Reference No: 2020/62/90492/W

Site Address: 27, Hill Grove, Salendine Nook, Huddersfield, HD3 3TL

Description: Erection of single-storey and first-floor extensions to rear, formation of pitched roof, and erection of front porch (modified proposal)

DECISION - REFUSED

PROPOSED FIRST FLOOR

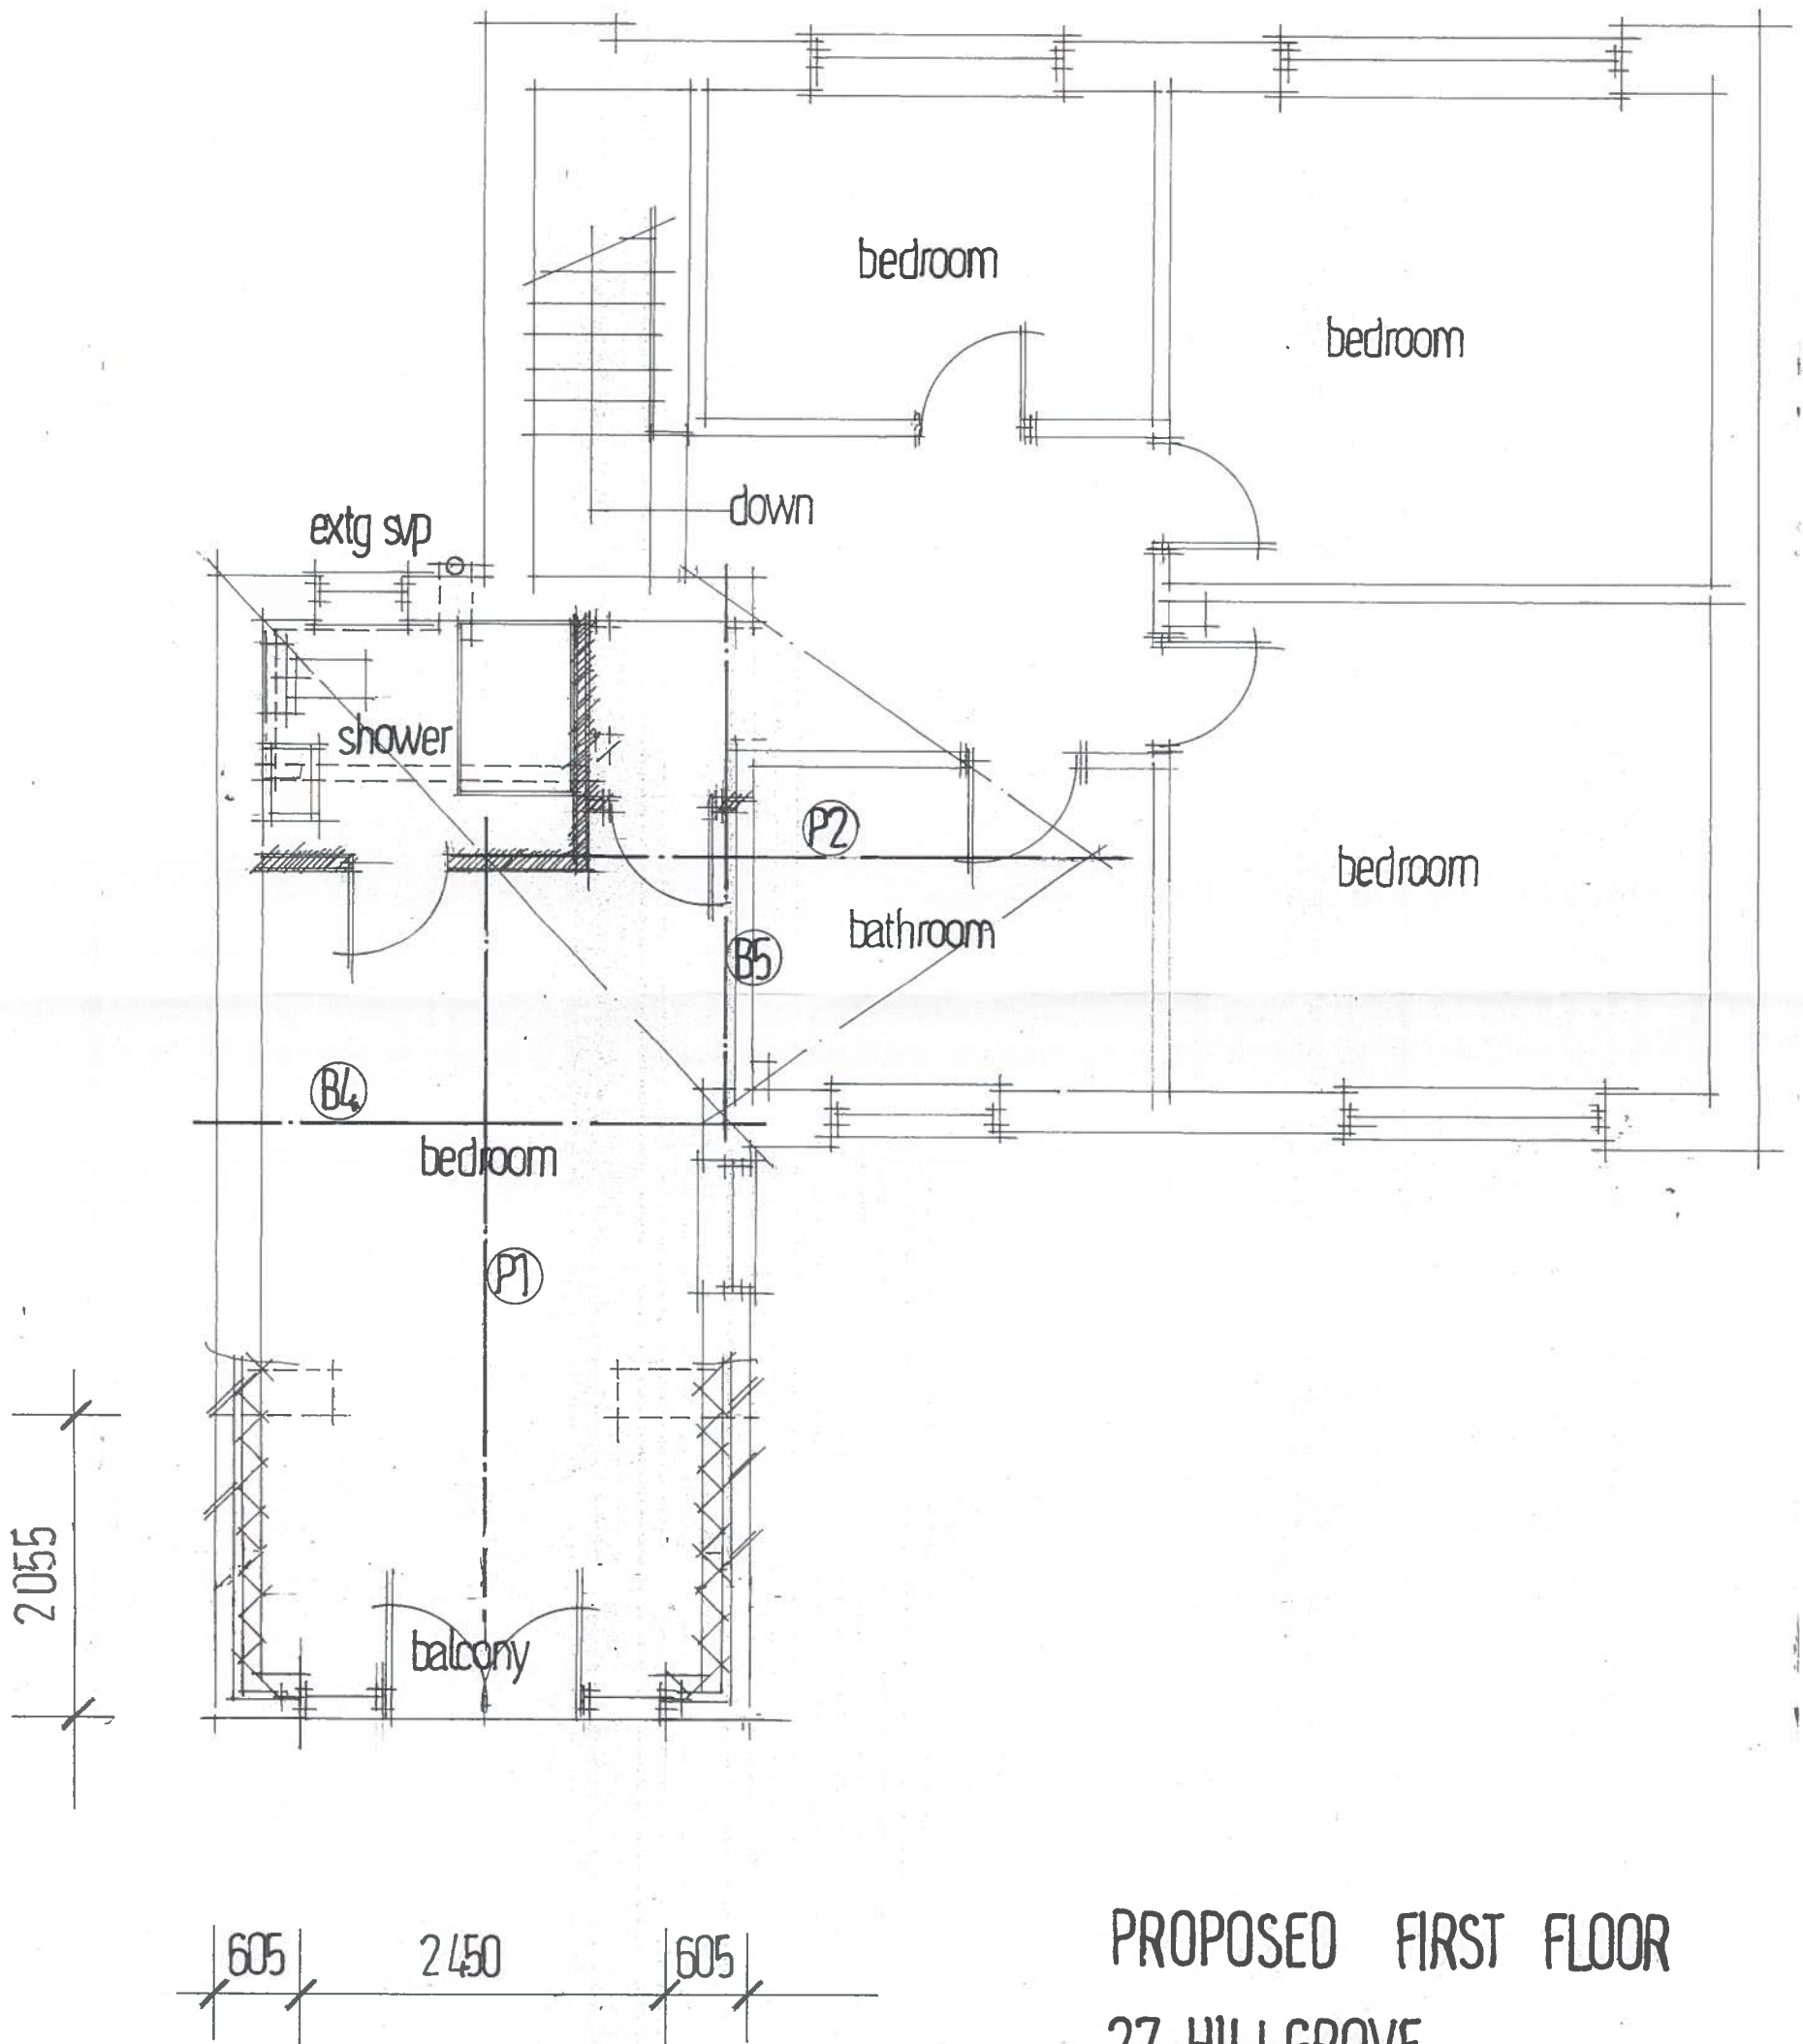
The works at first floor would involve the extension of the existing bedroom out and over the existing balcony by 2.0m so as to bring it in line with the floor below, the formation of a new gable roof over the bedroom as extended, and a new linking double-pitched roof connecting the extension roof to the main roof.

On the previous plans, the first-floor part of the extension would have been set back from the ground floor extension, leaving a small balcony. The new proposal would result in the first floor element of the extension being flush with the ground floor part below. Although representing a relatively small increase in overall volume, would, it is considered, make the extension appear bulky and overly prominent in the street scene and would leave the building with an unbalanced appearance.

3 – Impact on residential amenity: The bedroom extension would project about 3.75m beyond no. 25a's main elevation, or 750mm more than on the approved scheme.

It is considered however that the overall impact of the extension proposed would be materially greater than that of the approved first-floor extension under 2019/92395. It is officers' assessment that the combined impact of a substantial two-storey extension very close to the boundary line, and its being positioned to the south-west of no. 25a giving rise to greater likelihood of obstruction of sunlight to (especially) the nearer upper floor window, would result in the extension giving rise to a loss of residential amenity arising from overbearing impact.

ORG NO 1917-9_B SCALE 1:50

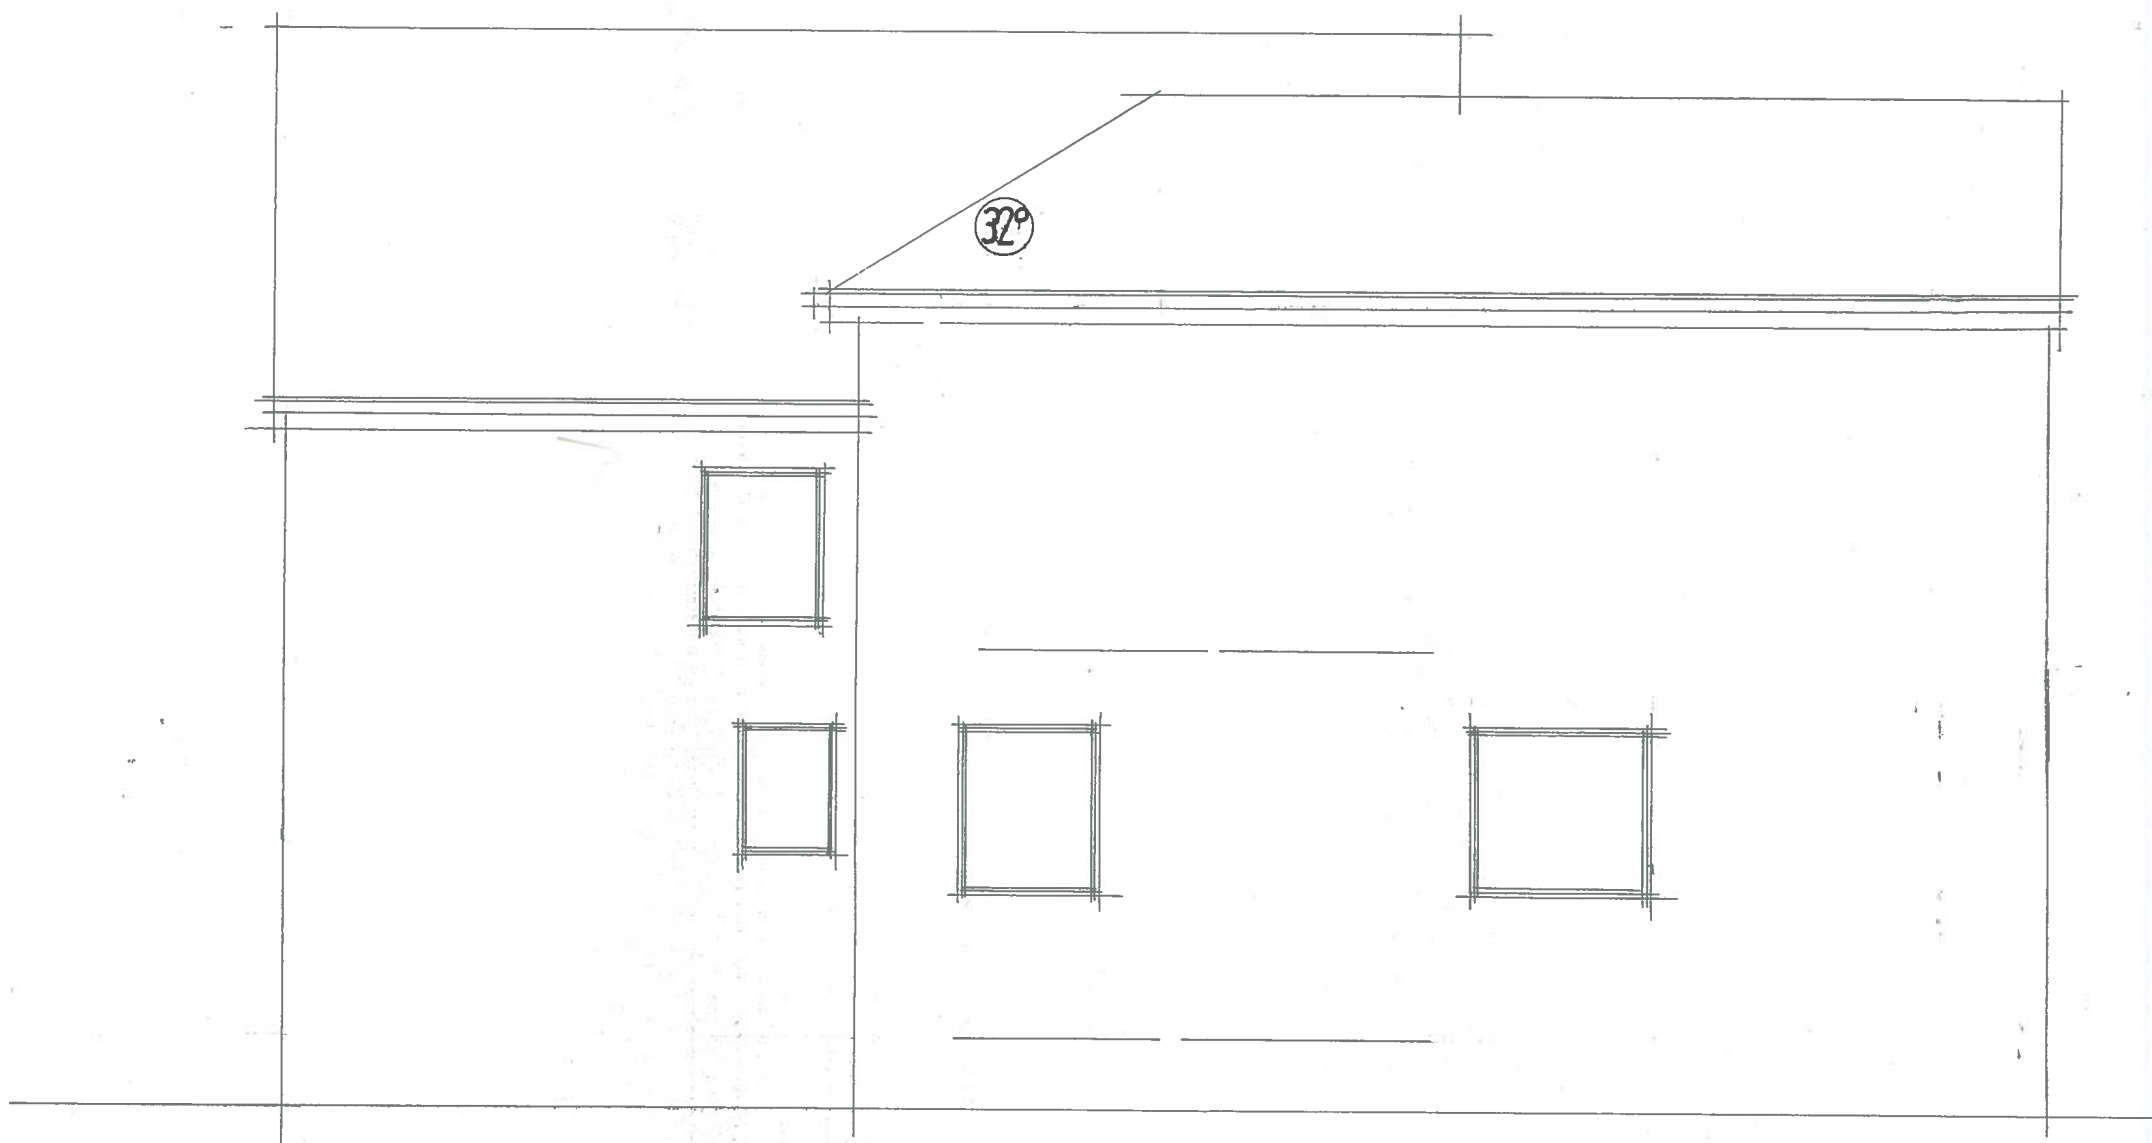
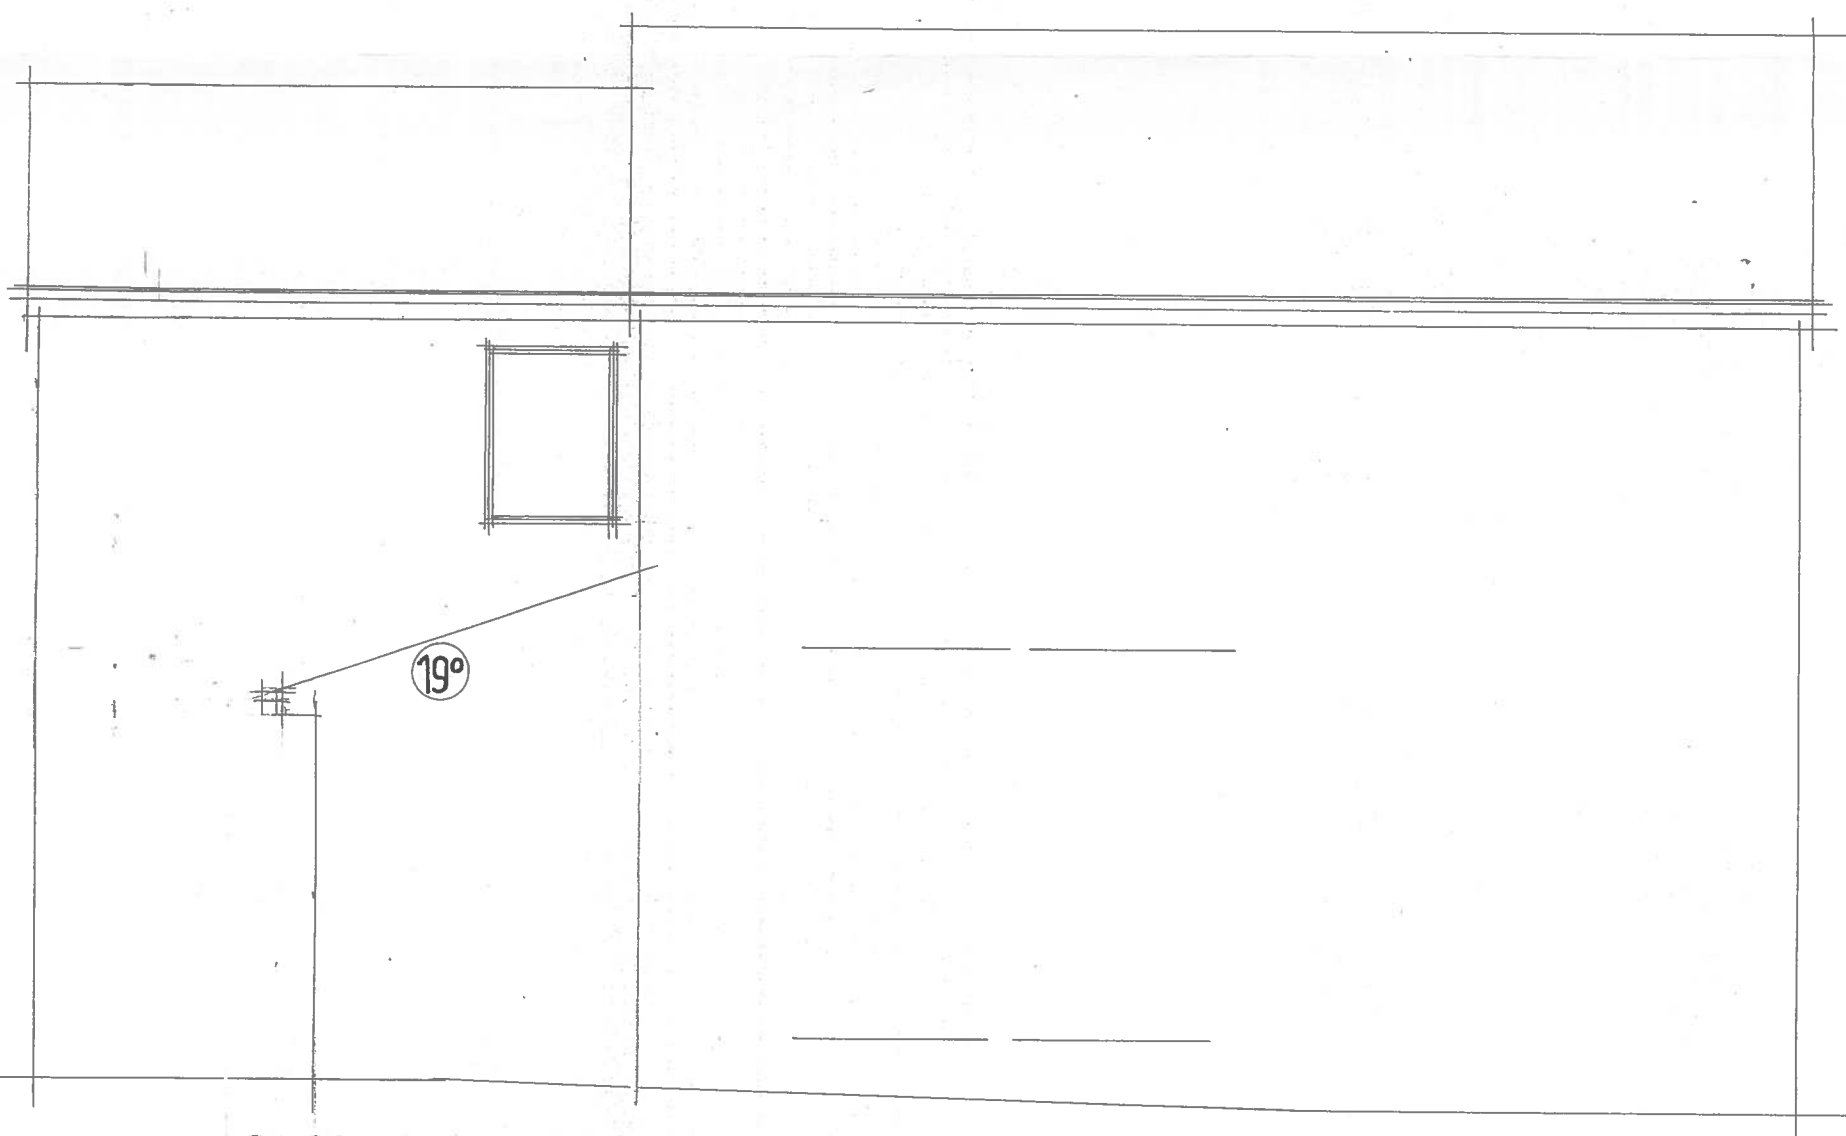
1. The proposed first-floor extension would appear as a bulky and overly prominent feature in the street scene and would result in the Hill Grove elevation of the dwelling having an unbalanced and incongruous appearance. The proposed development would therefore fail to respect the appearance of its surroundings and would not be in keeping with the existing building, contrary to the aims of Policy LP24(a) and (c) of the Kirklees Local Plan.
2. It is considered that the proposed first-floor extension, owing to its scale and siting in relation to the adjoining dwelling, would result in the extension giving rise to an undue loss of residential amenity arising from overbearing impact, contrary to the aims of Policy LP24(b&c) of the Kirklees Local Plan.
